Application No: AW/17/22/HH
Site Address: 11 Fish Lane Aldwick PO21 3AH
Description of works: Erection of two storey front and side extension and single storey side extension following the demolition of existing single storey extension.

Thank you for your internet representation made on 11th March 2022 which has been recorded as an objection with the comments as follows:

PROPOSED GROUND FLOOR PLAN

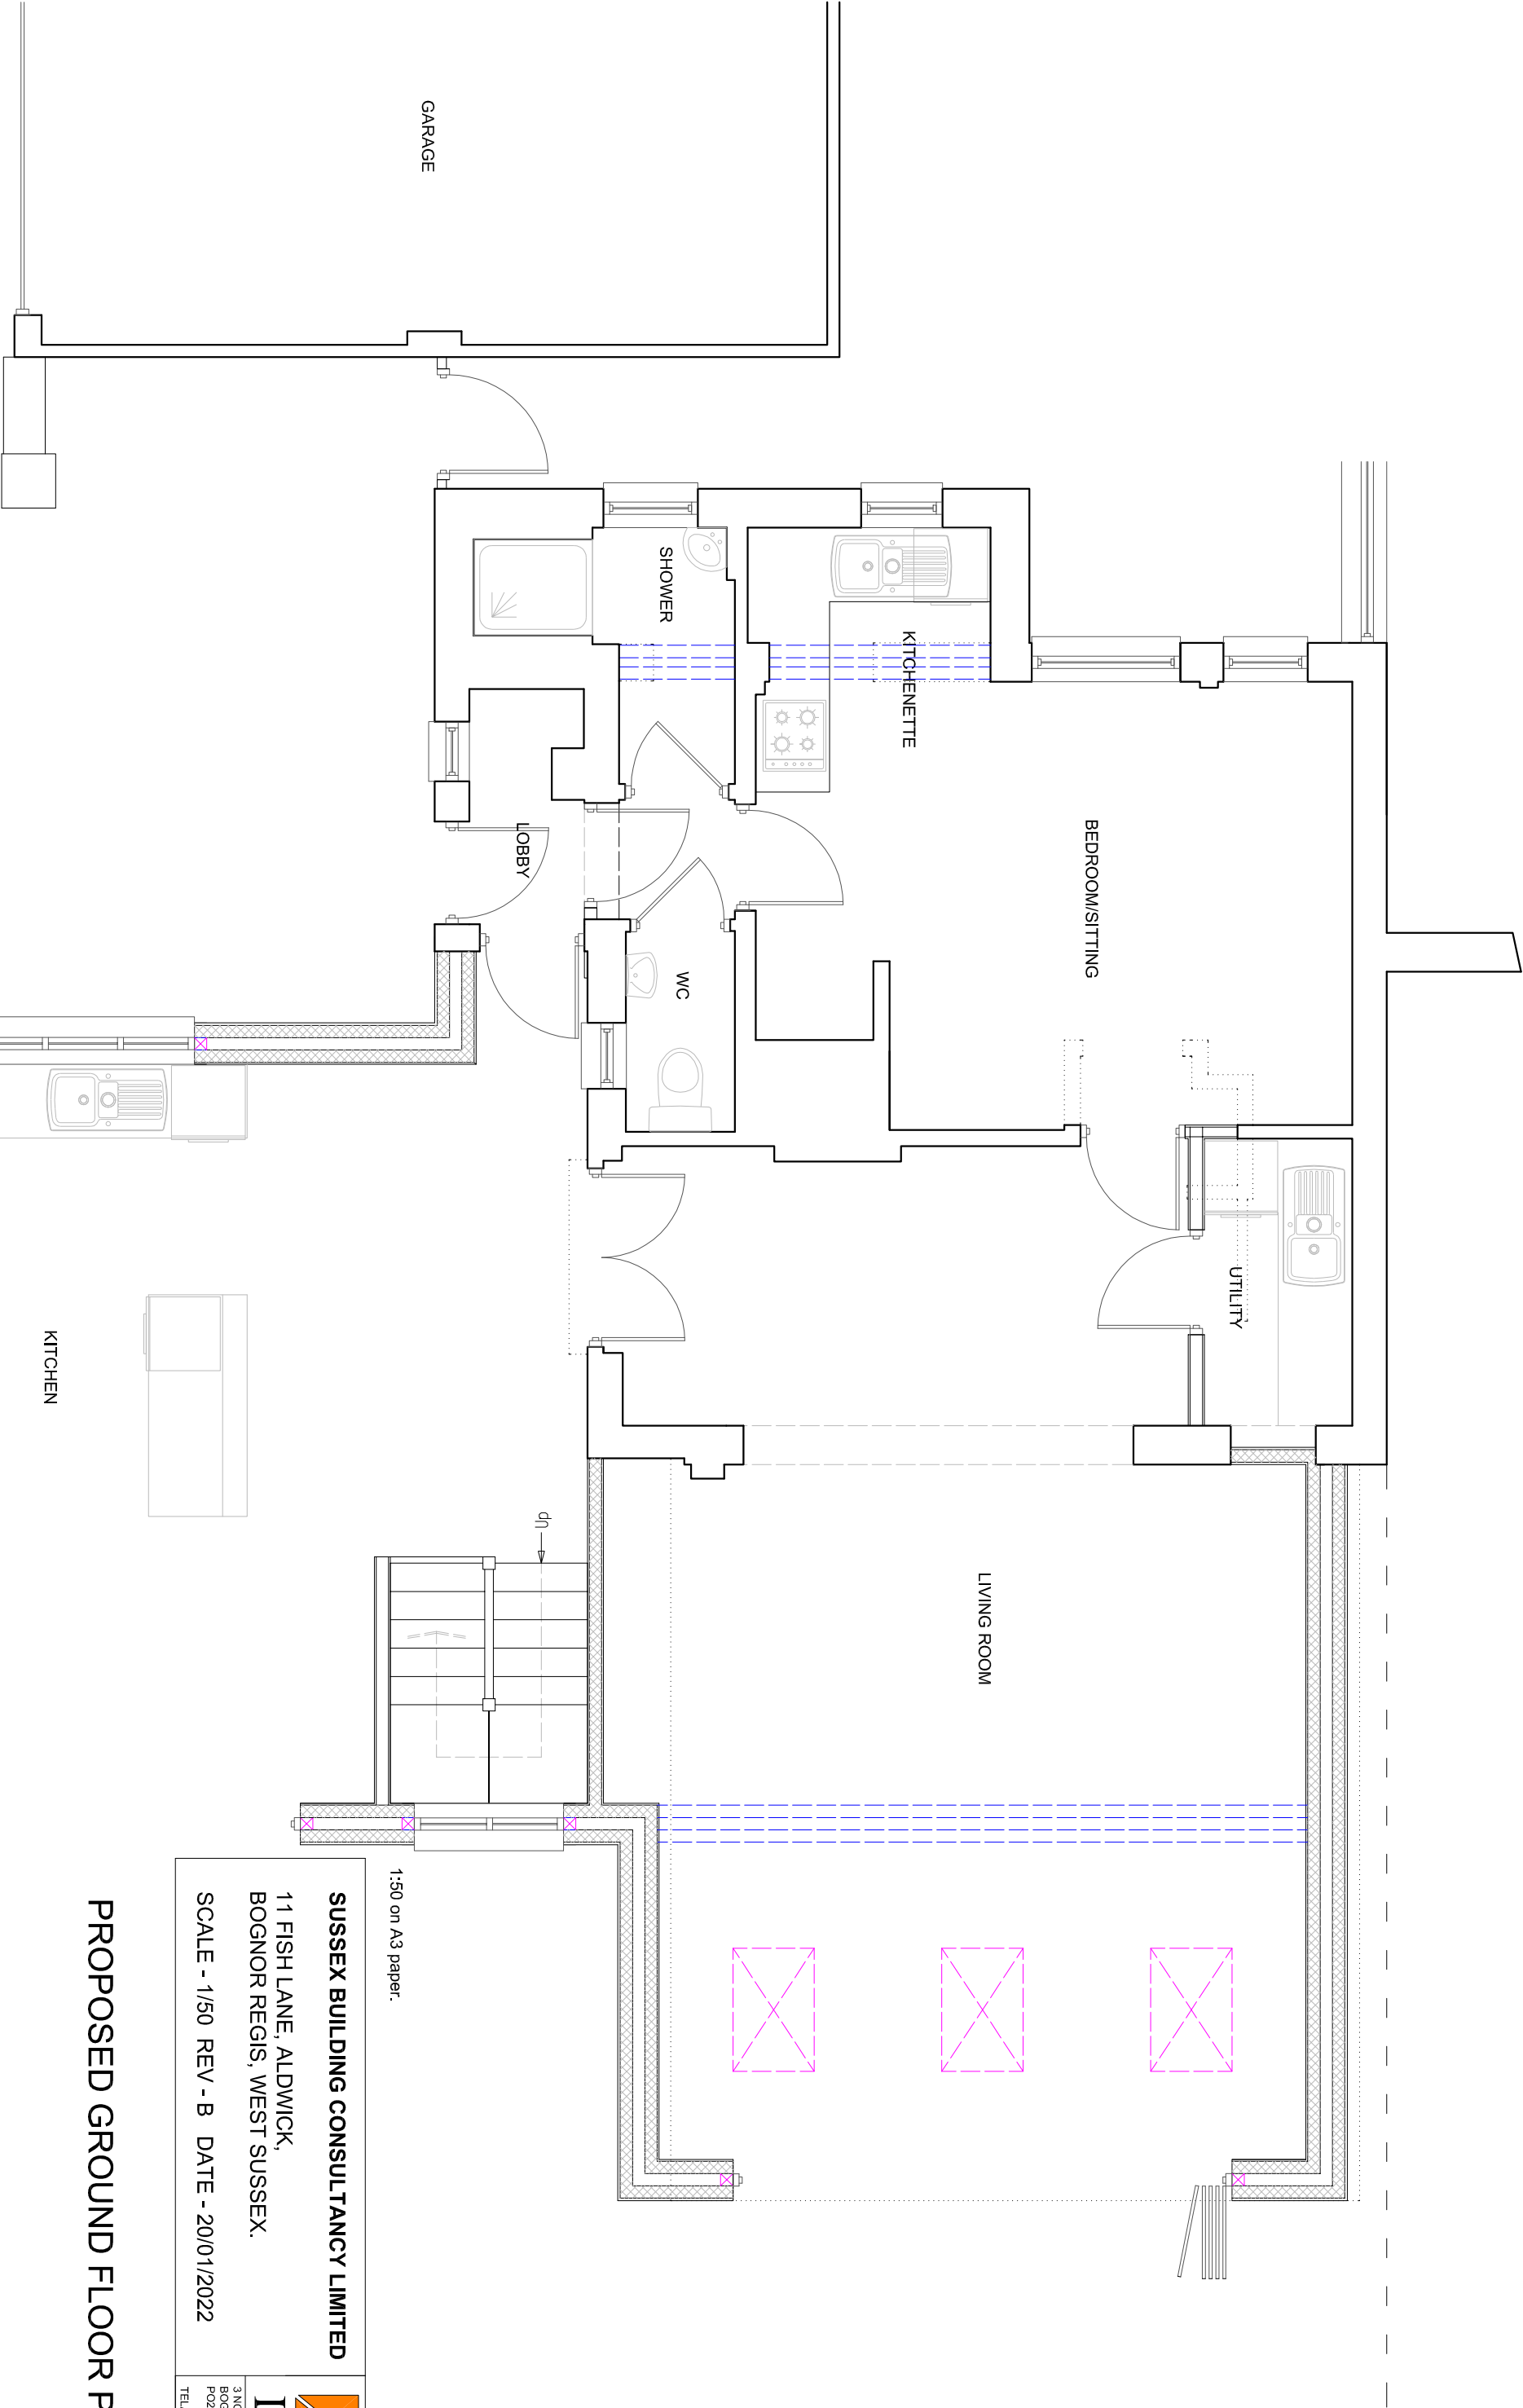
The extension will use up 25% of the existing drive-way which is already not appropriate for 2 vehicles, it will in no doubt push out even more cars on to the already dangerous fish lane. We had the same problem with the Carnot close development (2-8 fish lane) 20 years ago, where parking requirements were completely ignored resulting in the on going chaos we have to put up with today.
